VIVID Engineering Group, Inc.

Subject: Response to EPC and CGS Comments re: VEG Geology and Soils Evaluation Report
Project: The Markets at Bent Grass
Location: NEC Woodmen Frontage Road and Bent Grass Meadows Drive, El Paso County, CO
Project No: D25-2-928

SOILS & GEOLOGY NOTES

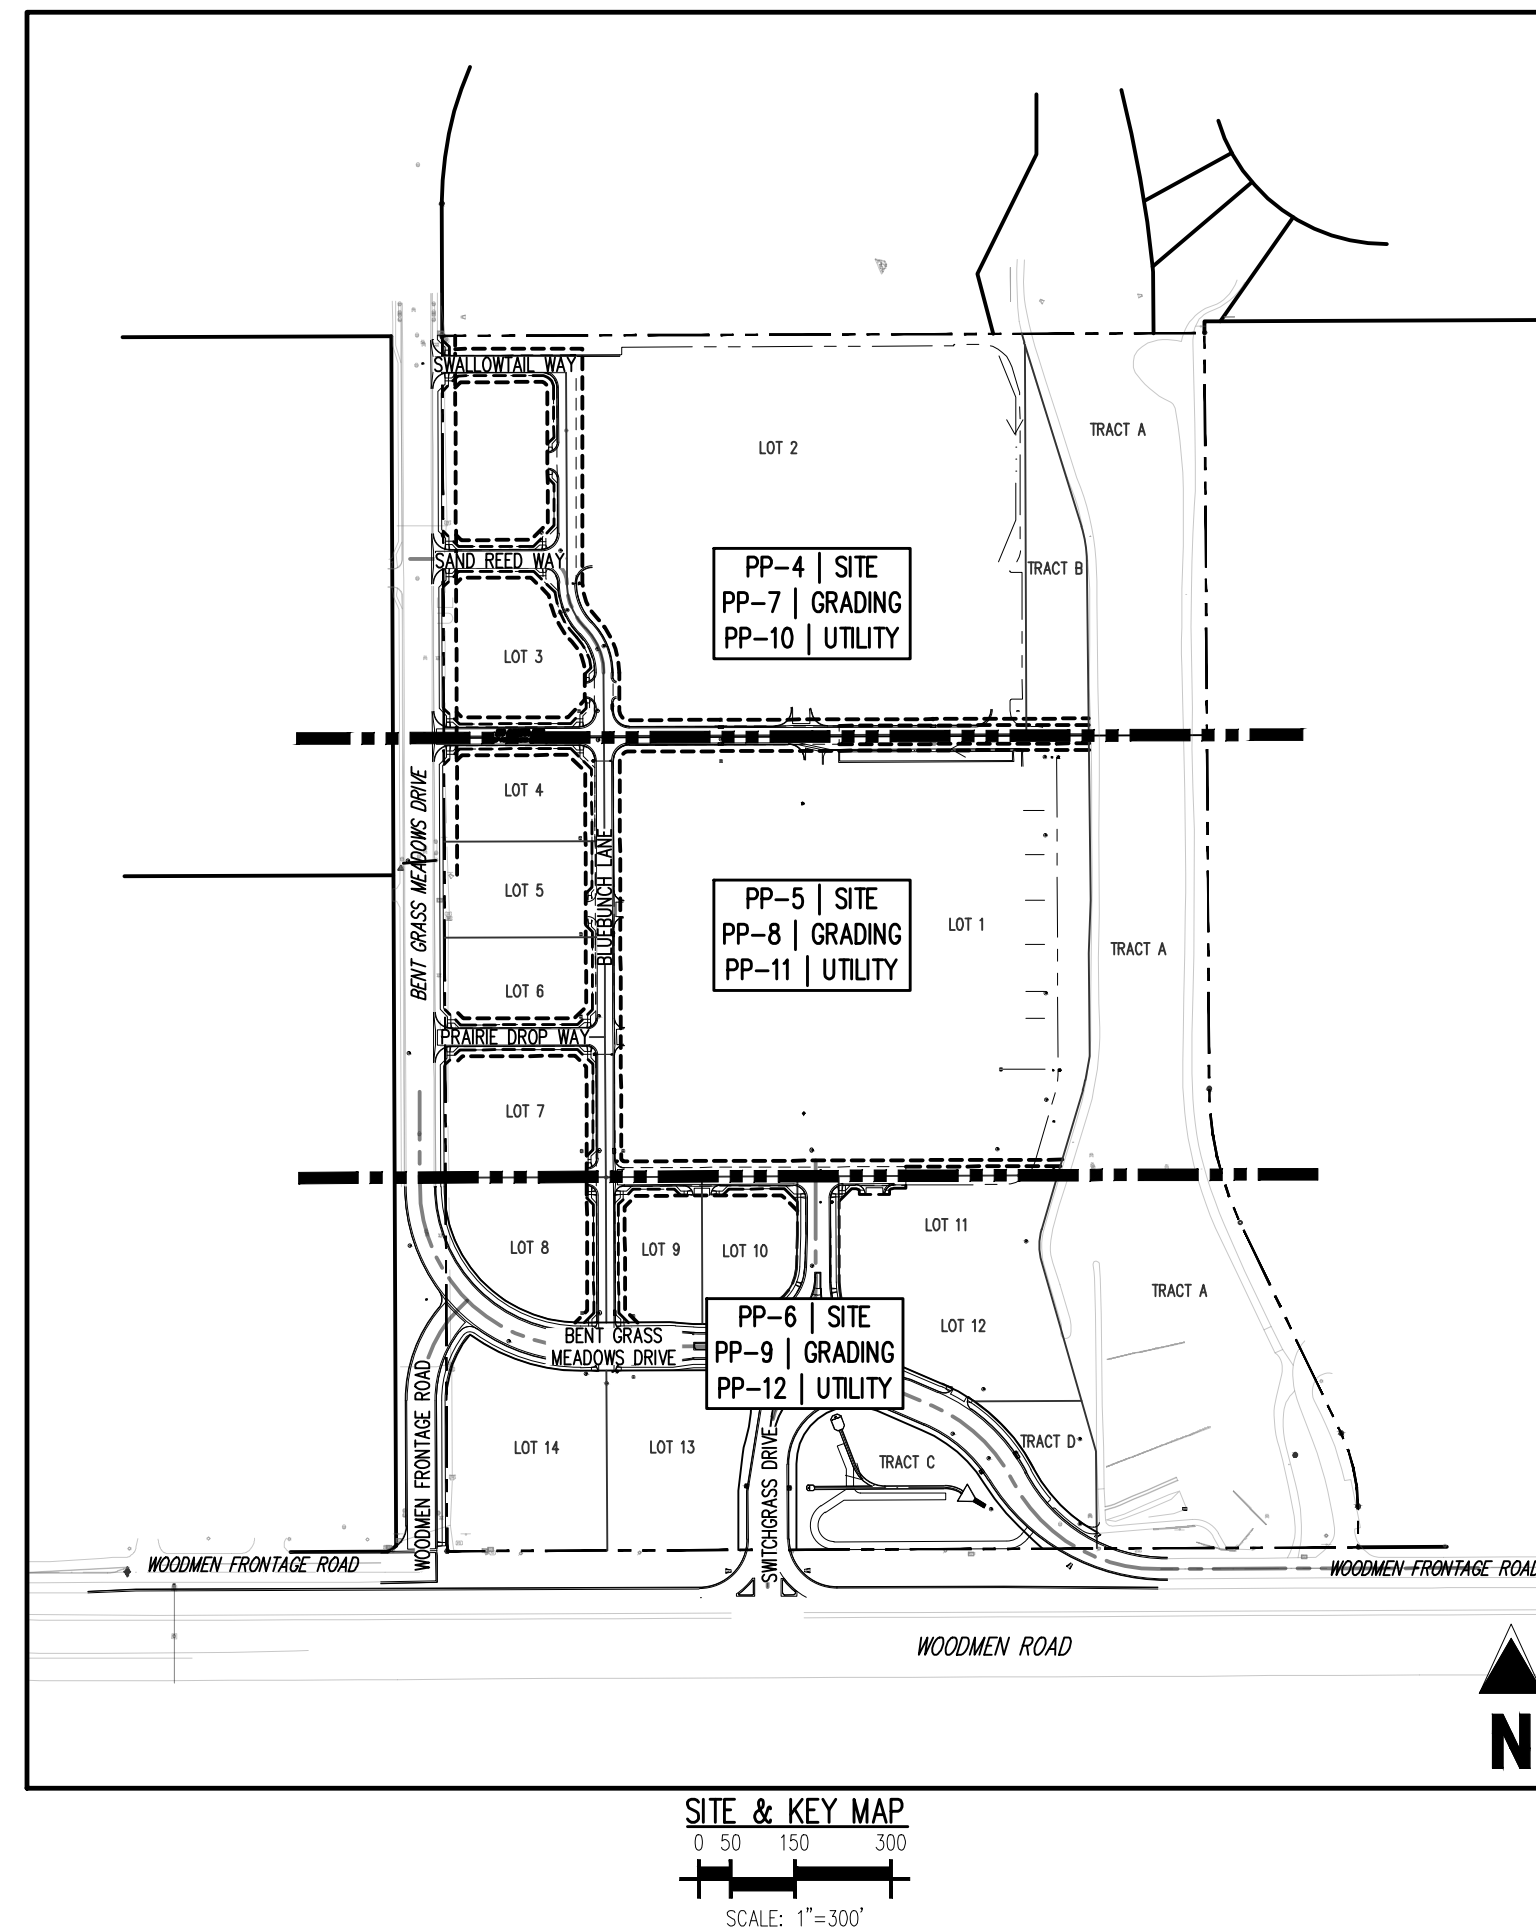
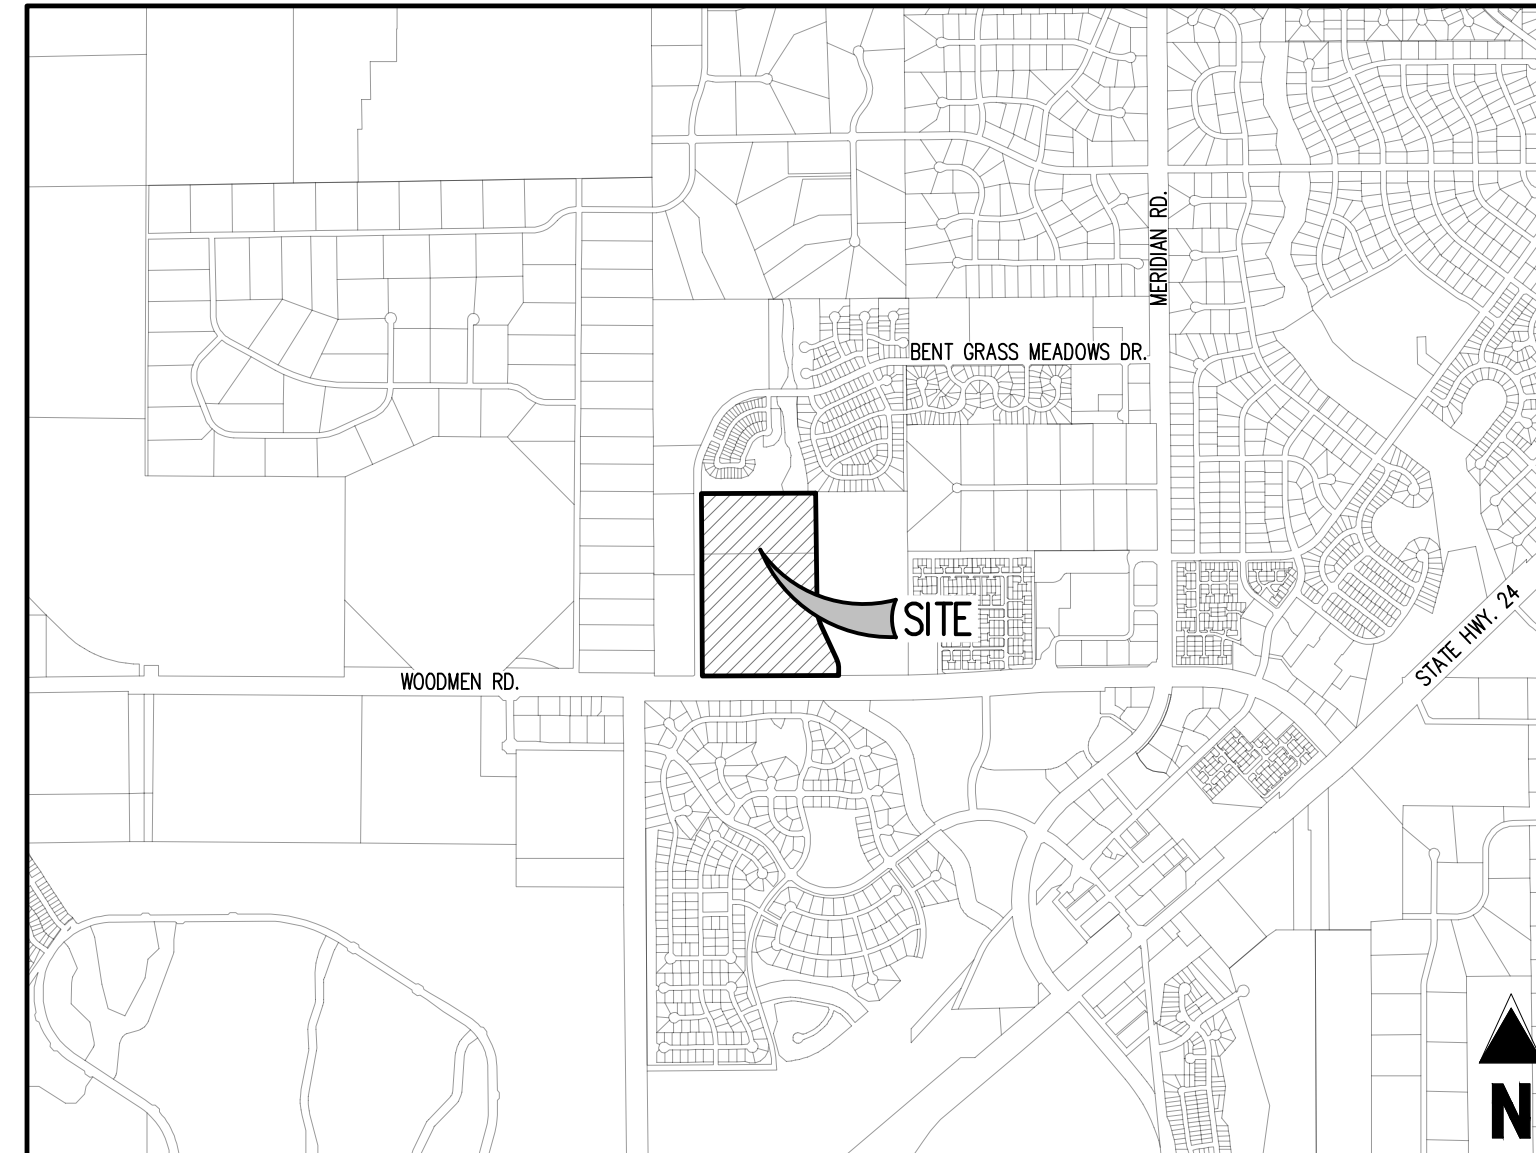
- *Note 2 of the preliminary plan (Soils & Geology Notes) lists the potential geologic hazards and constraints associated with the site; however, it does not provide mitigation measures, specifically for expansive soils, settlement-prone soils, and shallow groundwater. CGS recommends that mitigation measures be included in the preliminary plan. [CGS]*
 - [VIVID] The Geology and Soils Evaluation Report provides preliminary recommendations for mitigation of expansive and settlement-prone soils in the form of over-excavation and

replacement with suitable structural fill and further qualifies that site-specific subsurface geotechnical evaluations are required to provide site-specific mitigation measures for the applicable lot development. Lot-specific mitigation measures and techniques for control of groundwater will likewise be evaluated in site-specific subsurface geotechnical evaluations.
